CITY OF ALBUQUERQUE

**Re: Lobberegt Subdivision Conceptual Grading and Drainage Plan
Engineer's Stamp dated 1-9-05, (F23/D11)**

CONCEPTUAL DRAINAGE PLAN

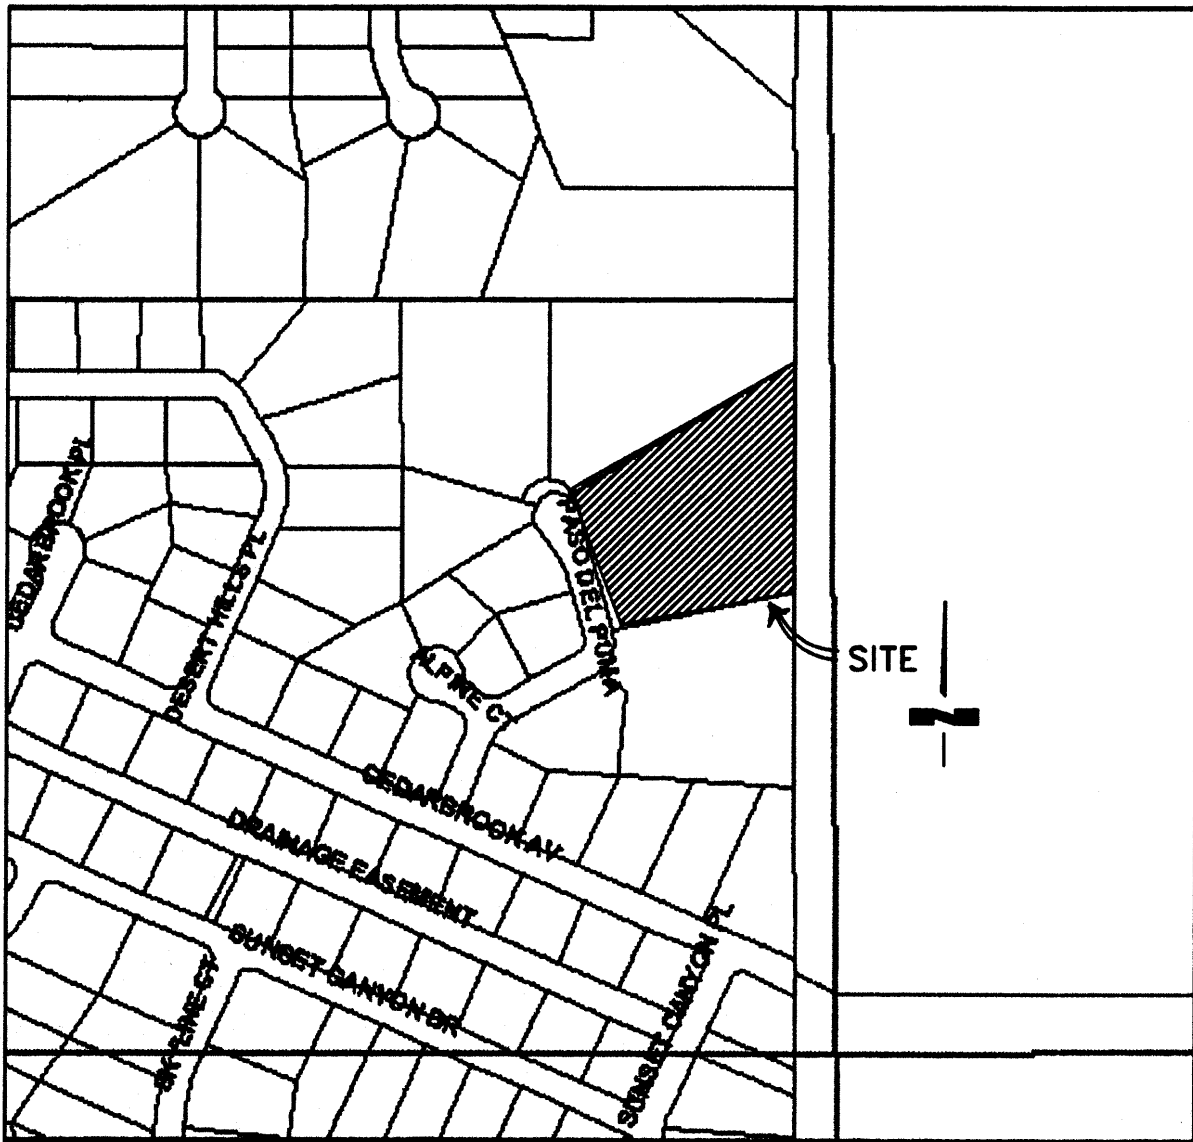
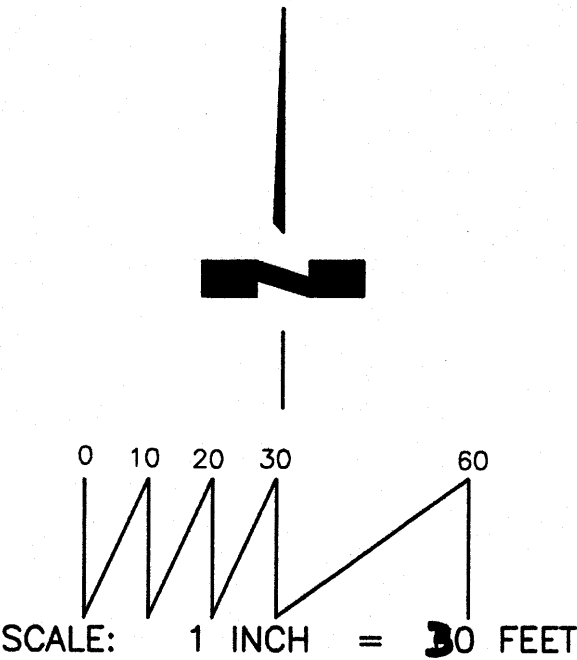
Based upon the information provided in your submittal dated 1-10-05, the above referenced plan is approved for Preliminary Plat action by the DRB. Cross-lot drainage easements will be needed on the plat.
